Your ref:	87c Saltram Crescent - FULL	Please reply to:	Phoebe Graham
Our ref:	20/08350/FULL	Tel No:	07971 024216
		Fee Queries:	0207 641 6500;
		Email:	planningreception@westminster.gov.uk;
Mr George Kain Fast Plans 6 Winsham Grove London SW11 6ND www.fastplansuk.co.uk		Incomplete Applications Development Planning City of Westminster PO Box 732 Redhill, RH1 9FL	
			15 January 2021

Address: Second Floor Flat, 87 Saltram Crescent, London, W9 3JS,

Proposal: Erection of rear dormer and installation of Velux windows to front elevation and skylights to rear roof.

Scale: 1:100 @ A3 Dwg. no: A09 REV1

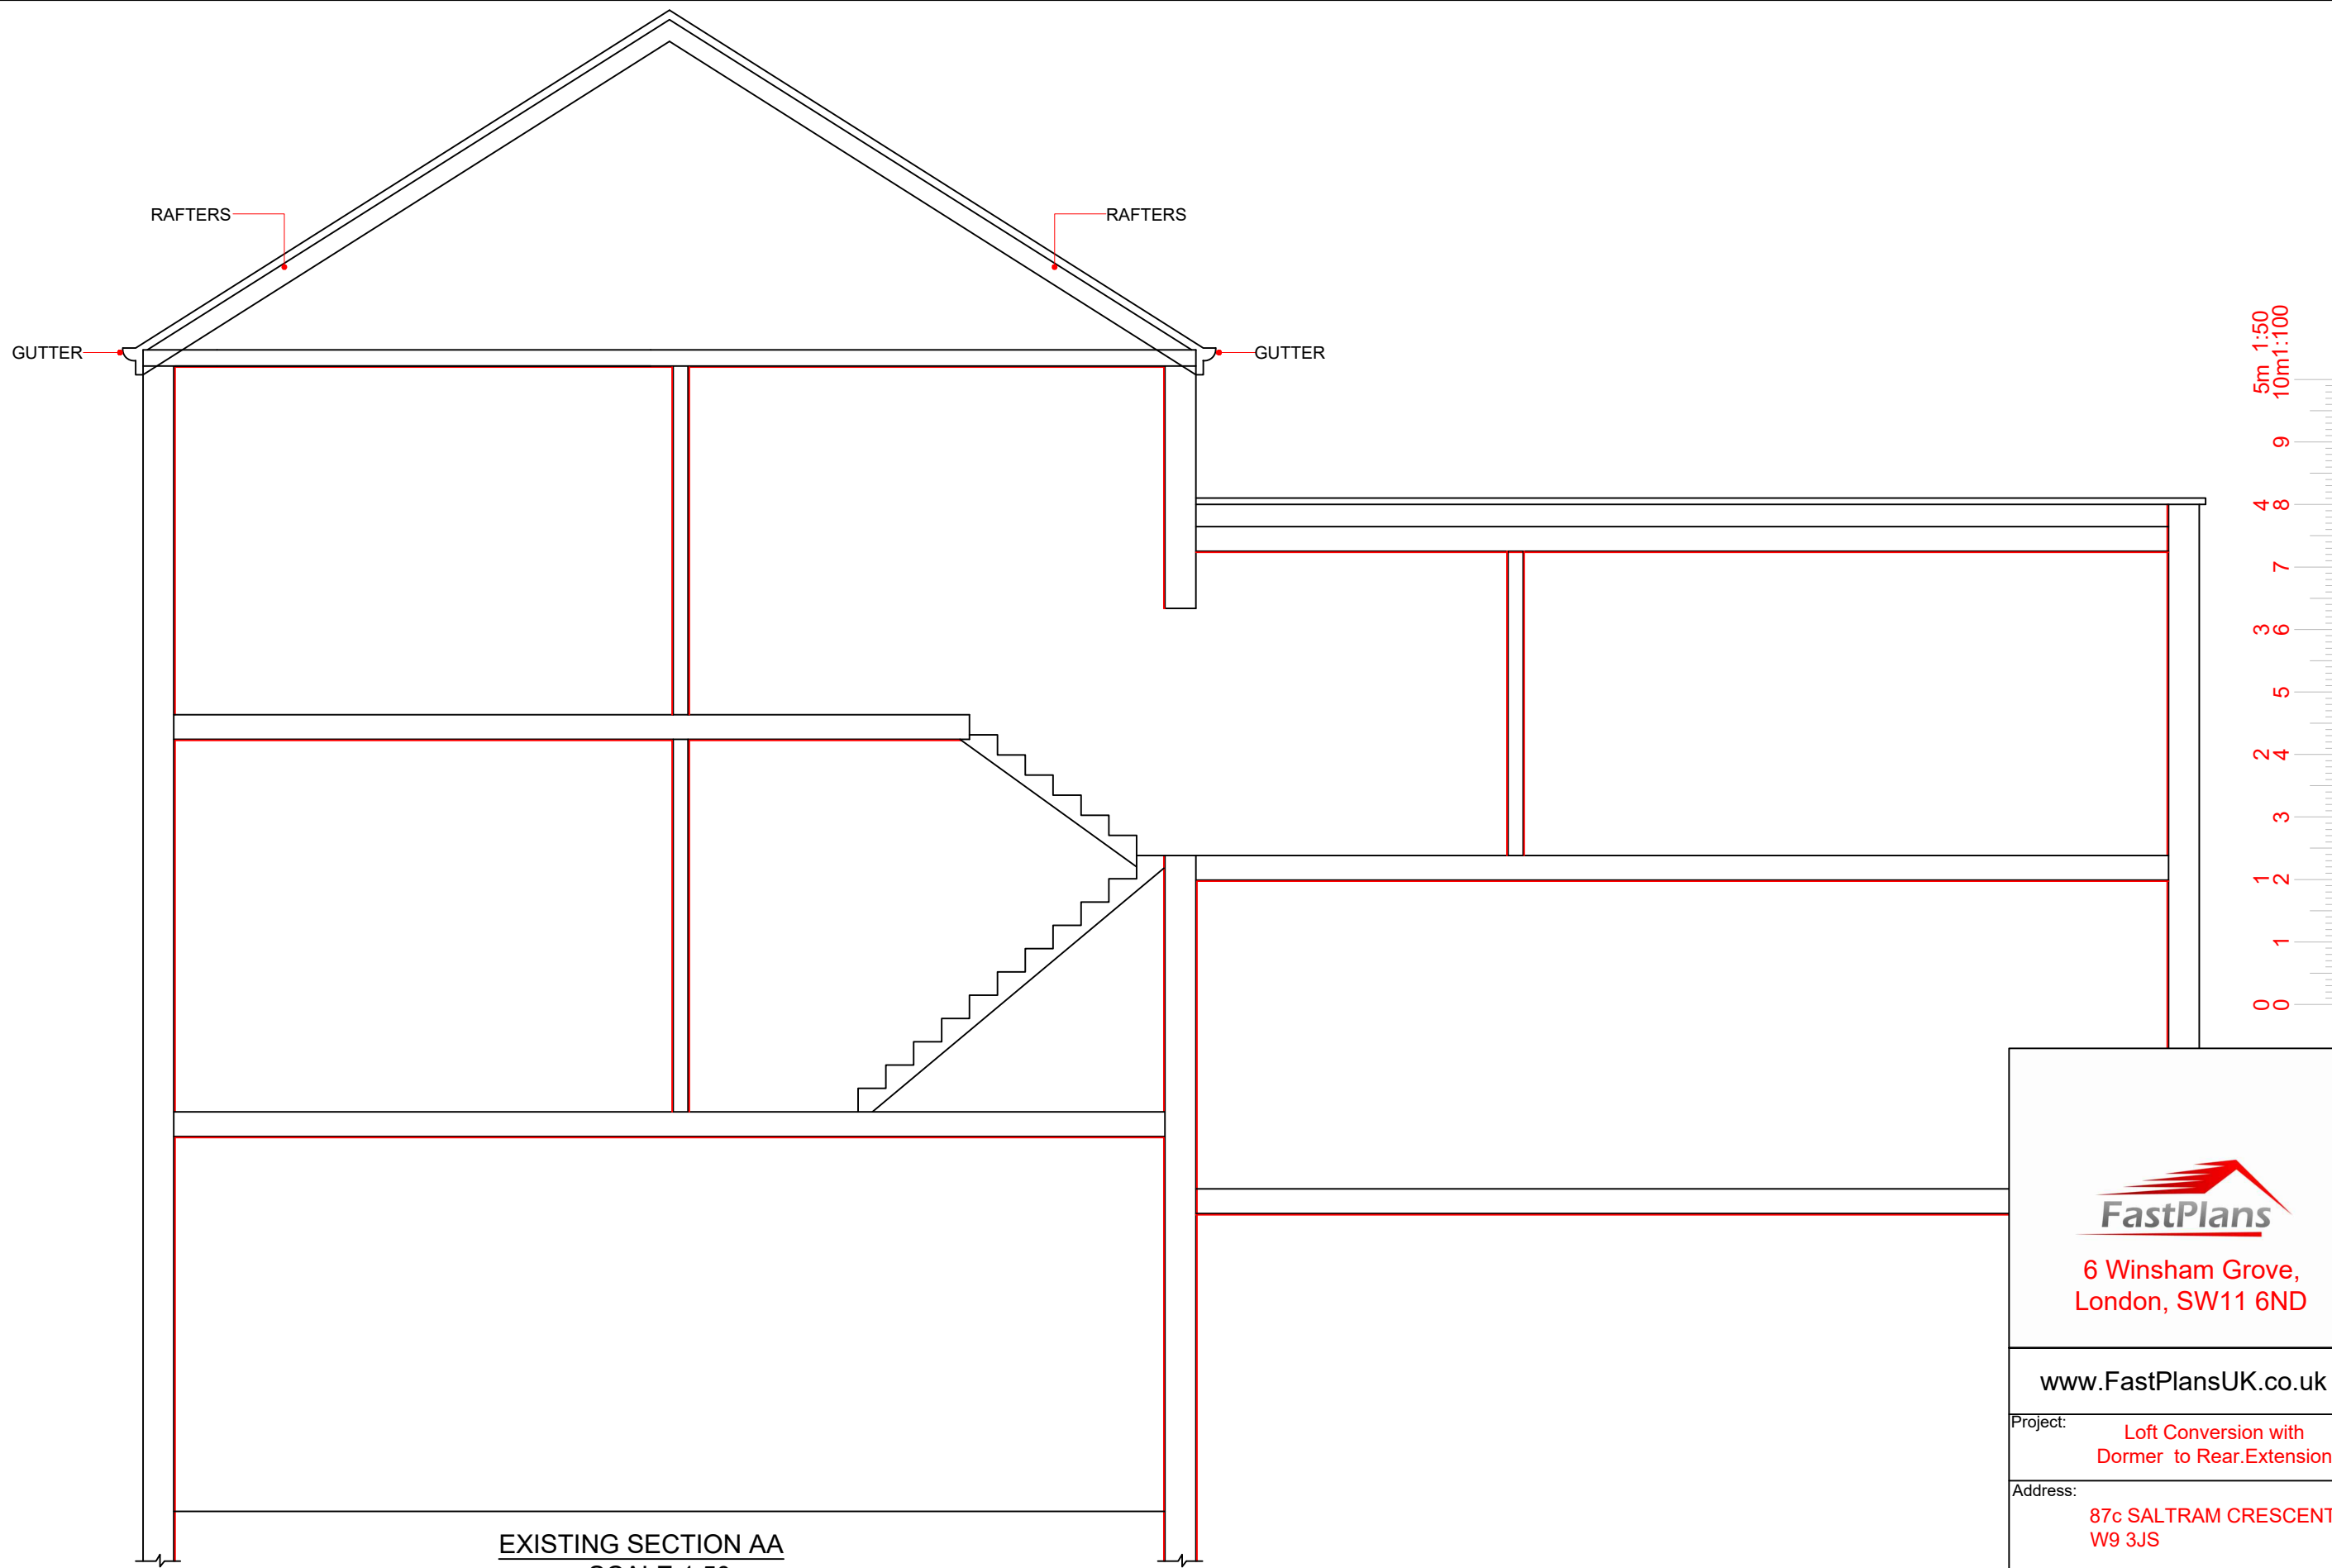
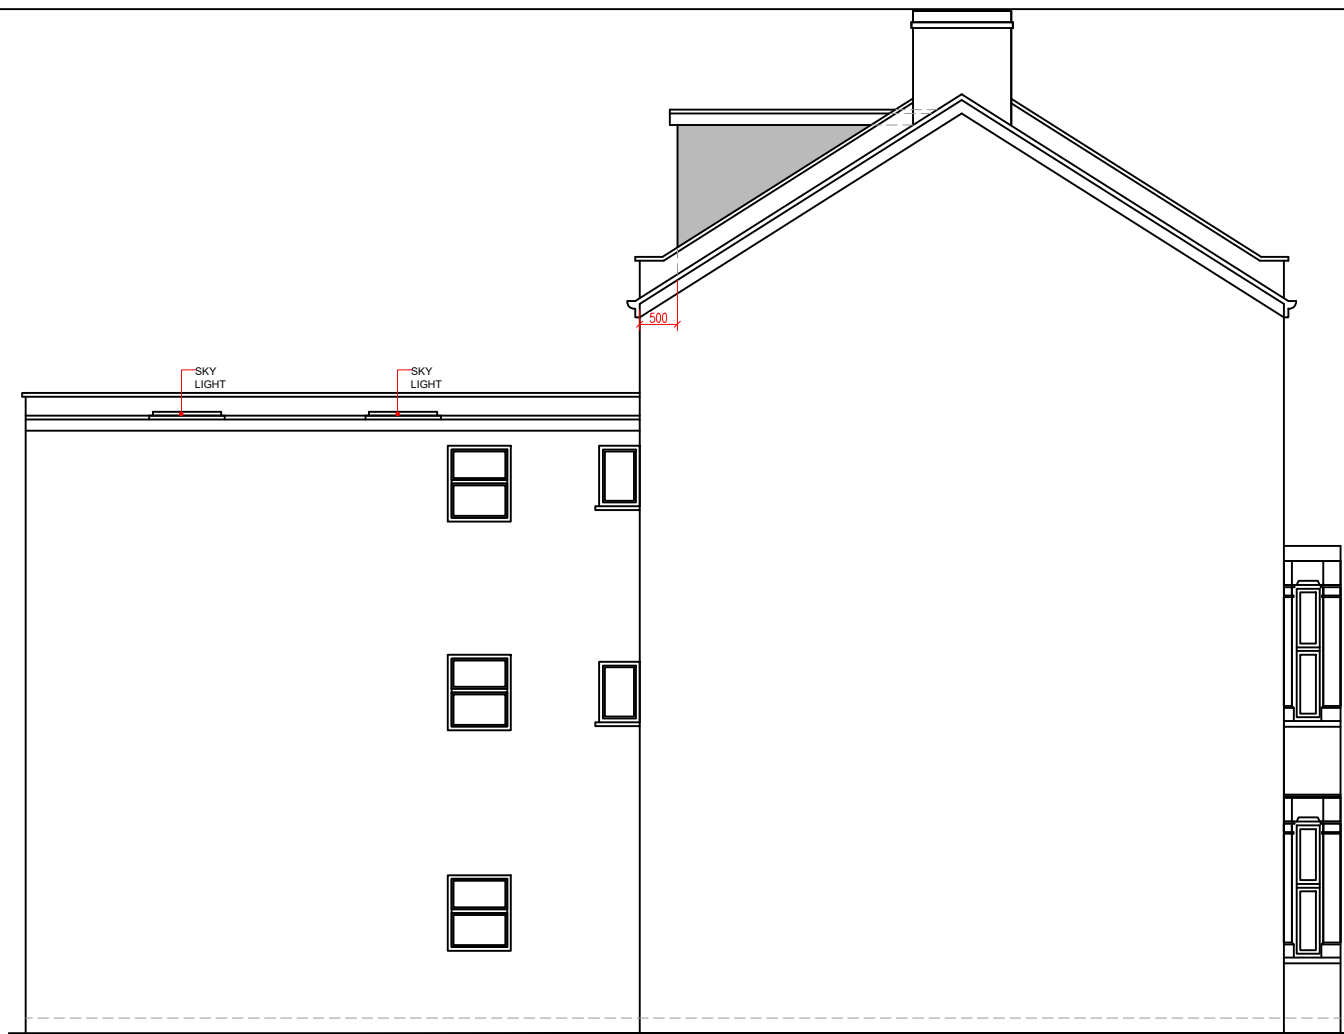
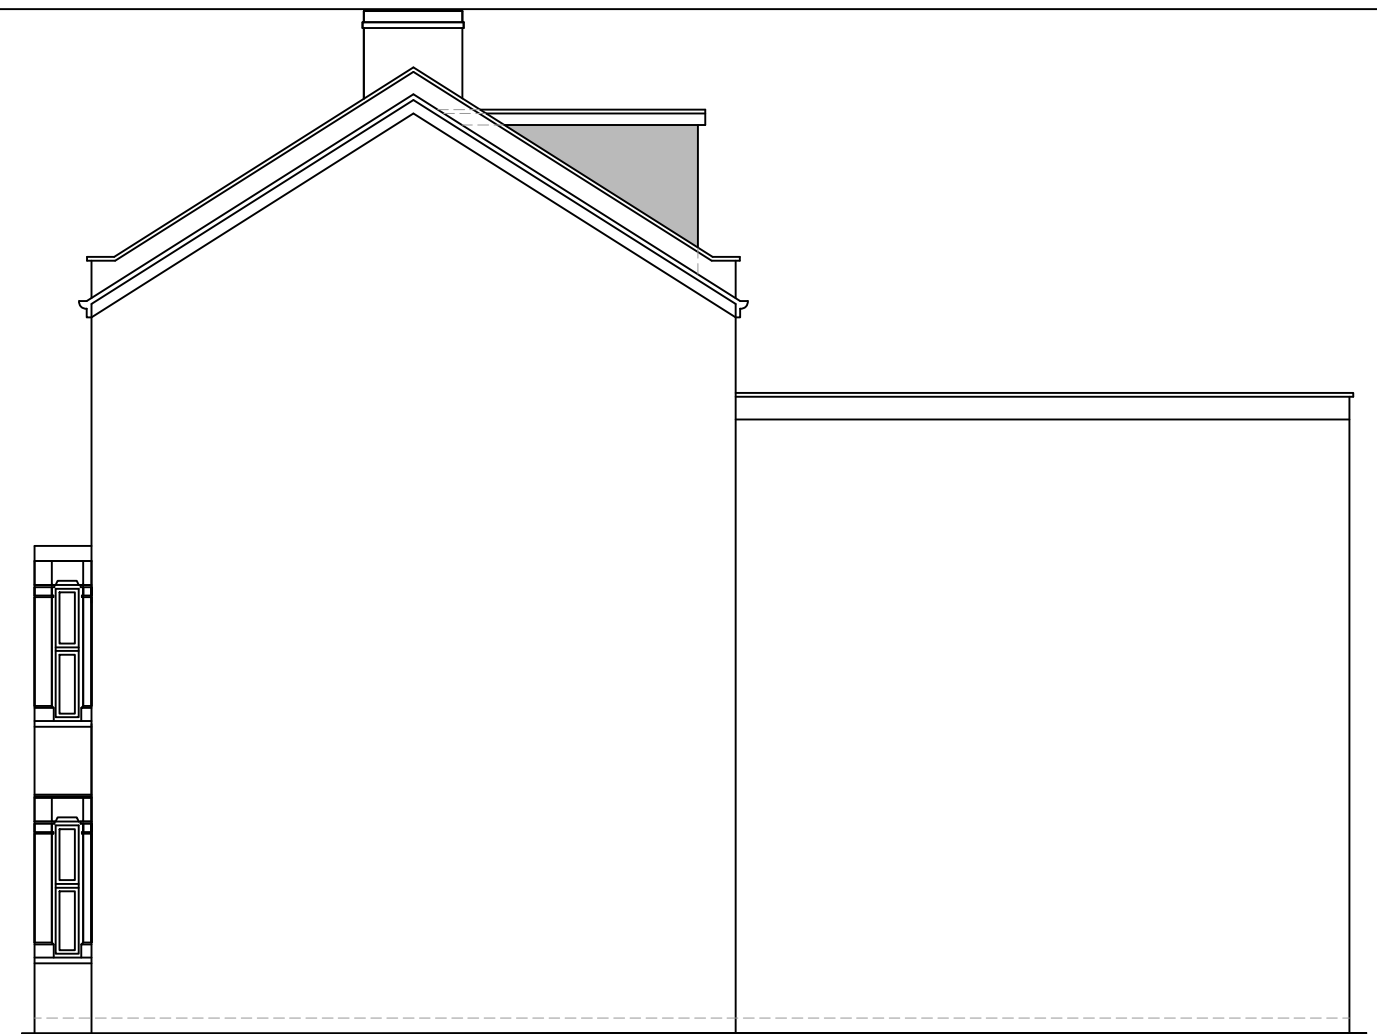
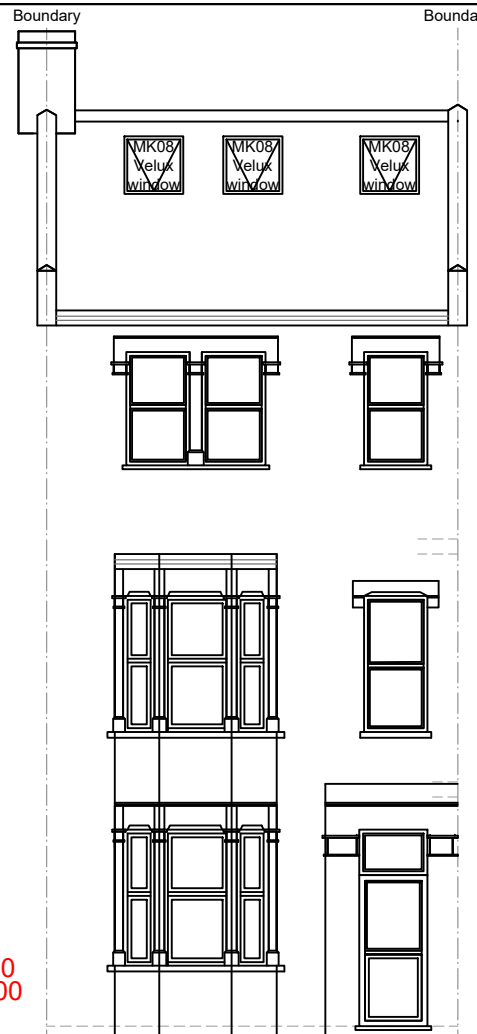
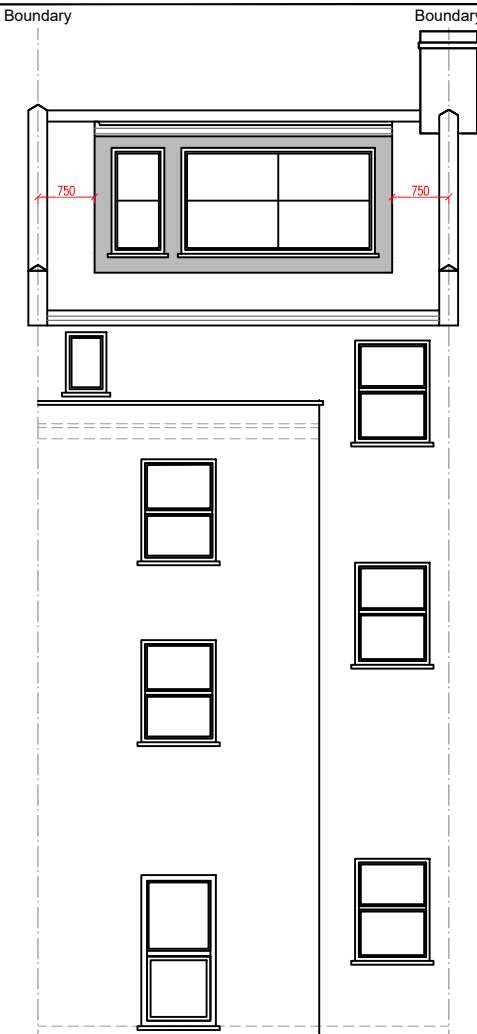
- 1 It appears that the Certificate of ownership/ notices served doesn't include the lower floor flats. Can you please confirm if there are any leaseholders of the properties that need to be notified of the works.
 - 2 In terms of detailed design of the dormer extension I would draw your attention to the Council's SPG Roof Extensions (please see our website) which generally requires dormers to be set in from edge by 1m and from the ridge by 1m and the windows should be more appropriately detailed.
- 0 *Please collate all requested information in a single submission, and send to planningreception@westminster.gov.uk. Sending your documents individually will not speed up the process. Please do not upload to the planning portal as this causes duplication and may delay the processing of your application. Thank you.*
